Our ref: WA/2015/120640/05-L01

Your ref: TR010019

**Summary Of Written Representations
Development Consent Order Application M4 - Junctions 3-12 (Smart Motorway)**

**Written Representations
Development Consent Order Application M4 - Junctions 3-12 (Smart Motorway)**

Thames Bray Re-alignment
Chainage 31400.000 Work No. 9a
Works Plan Sheet 19

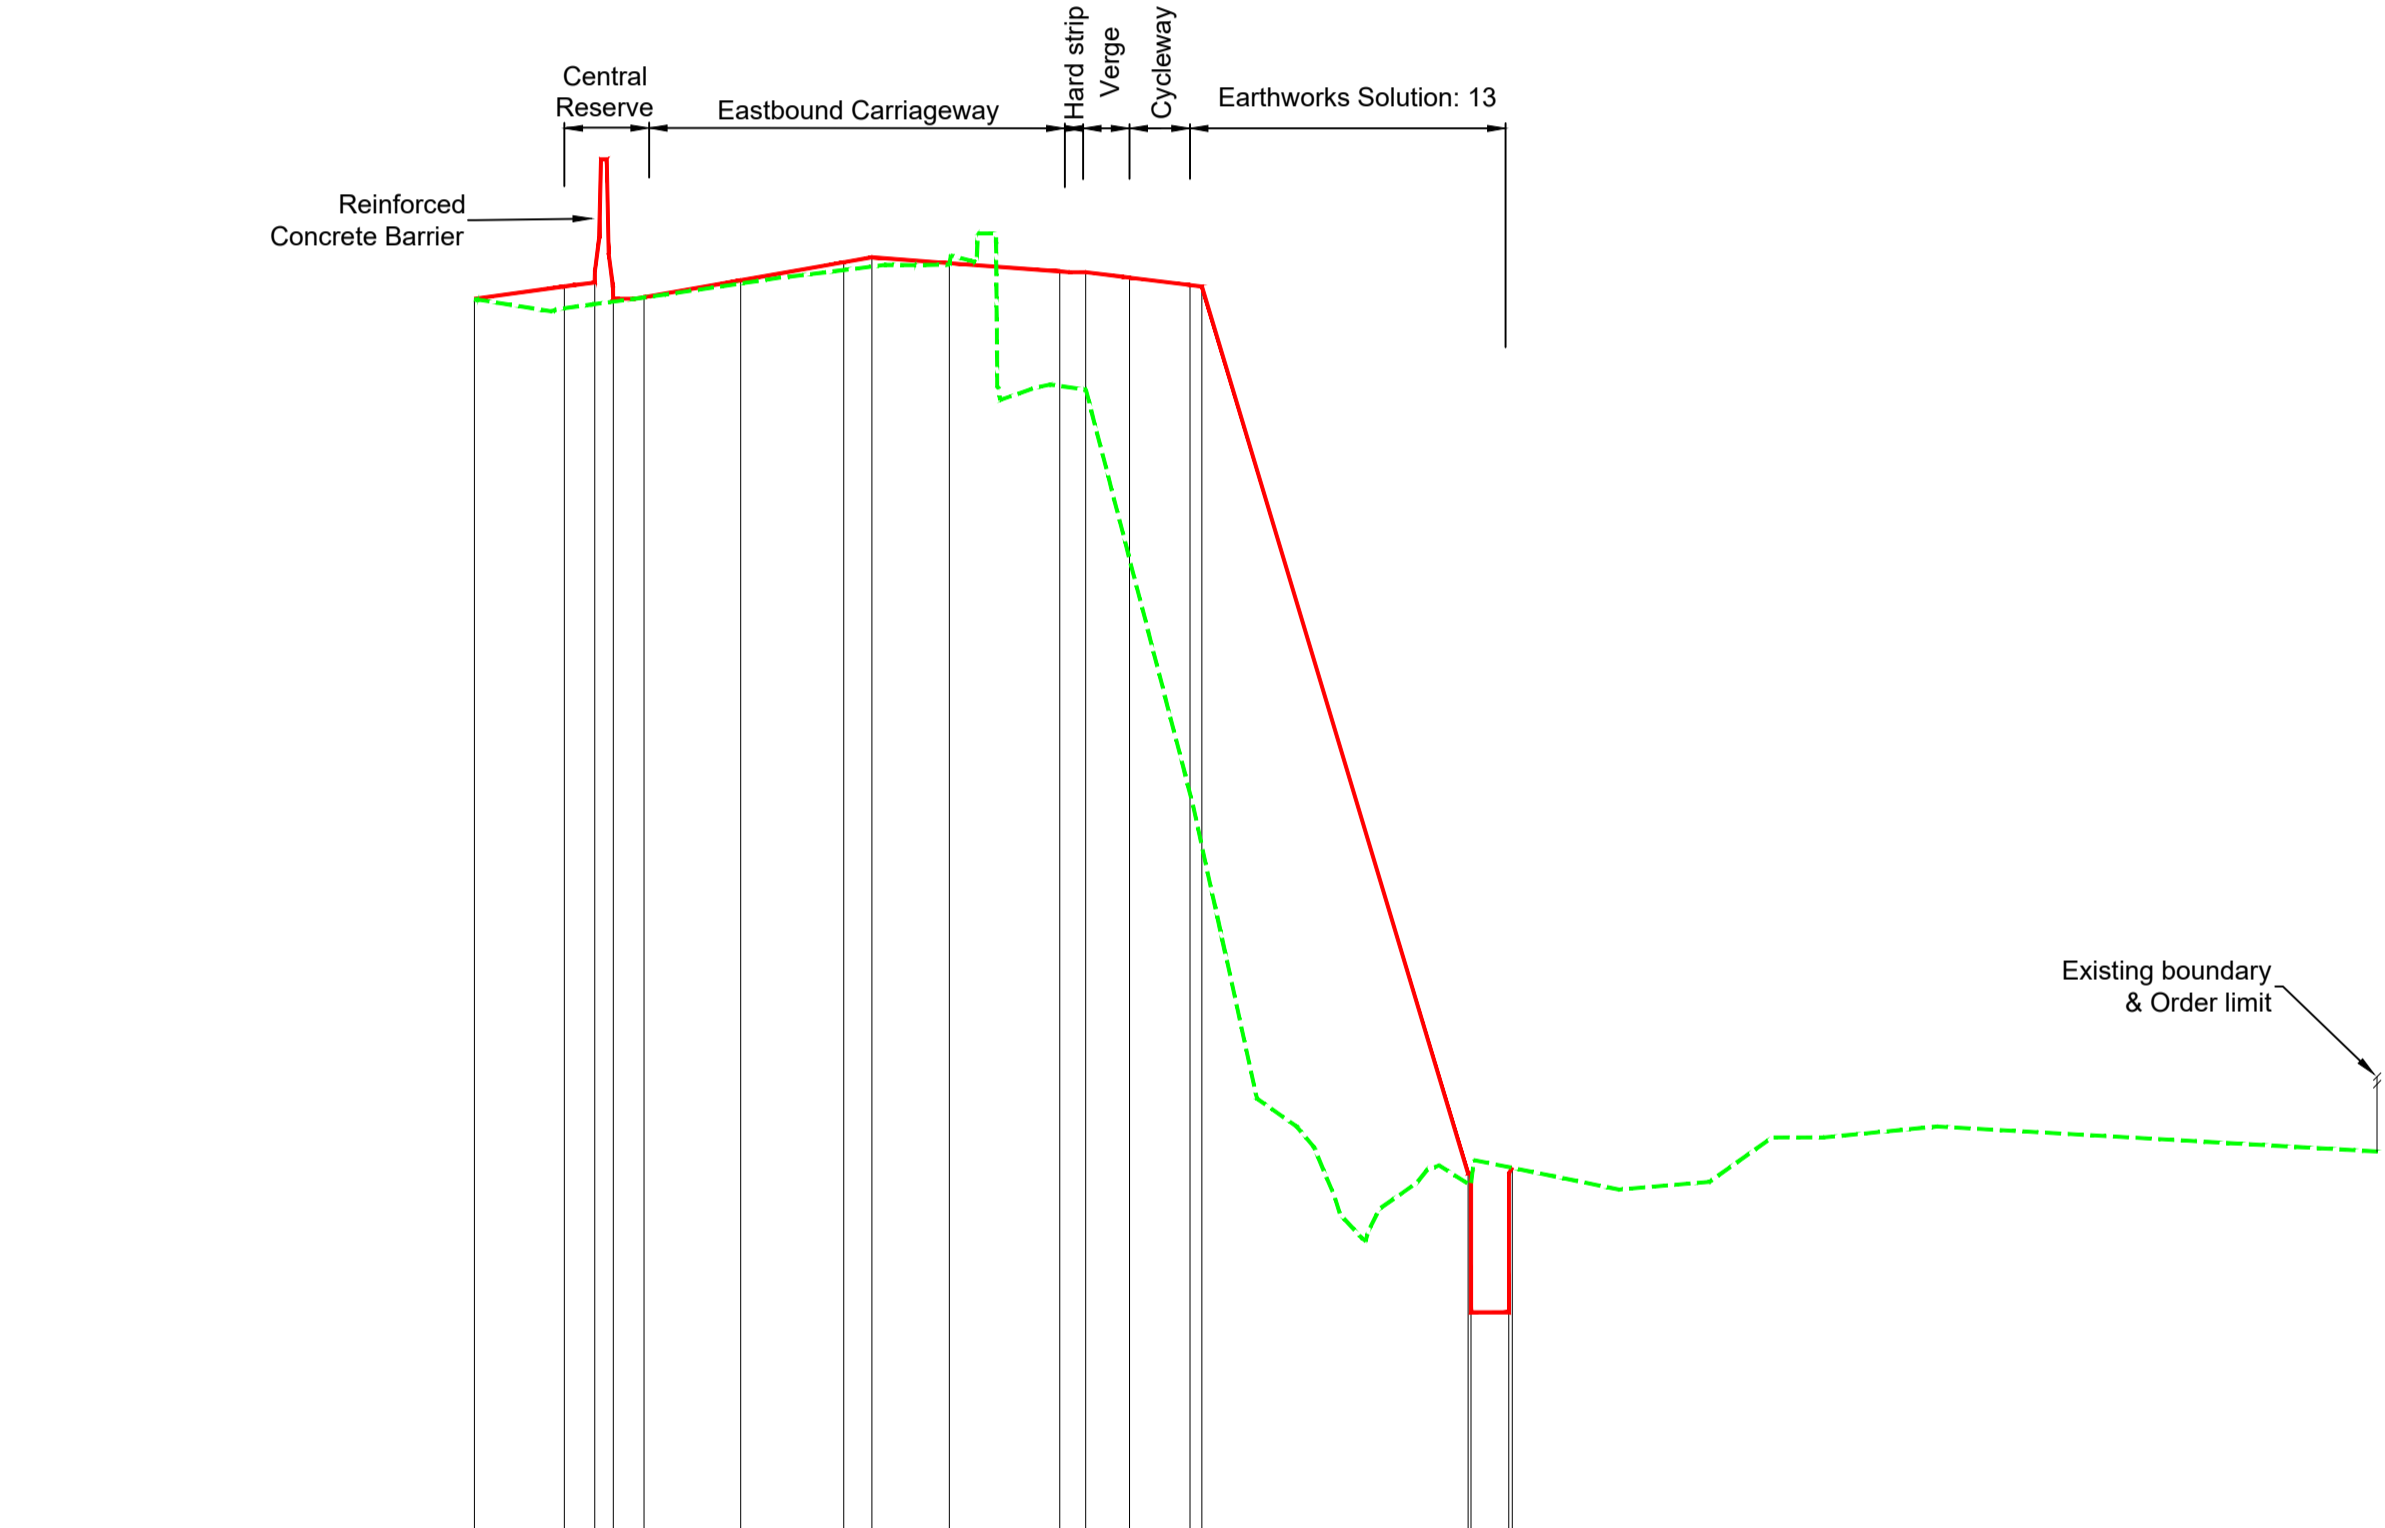
1.5 RR Issue 1.5 – Widening of the Thames Bray underbridge

'The FRA states 'Widening of the Thames Bray underbridge would result in a total river bed displacement of 50m². The impact of this displacement is considered to be negligible. However, to minimise the impact on any hydraulic conveyance capacity of the river, if required, mitigation measures such as

If not appropriately compensated for the increase in built footprint may reduce flood storage and also impact on flood conveyance thereby increasing the risk to others. If losses of floodplain storage have not been properly quantified then we cannot be certain that flood risk will not increase as a result of the proposed works.

EA proposed solution 1.5: *The applicant in the FRA should quantify losses of floodplain storage and demonstrate that there is sufficient space on site to be able to provide level for level compensation to demonstrate no loss of floodplain storage up to the 1 in 100 year with an allowance for climate change flood level.'*
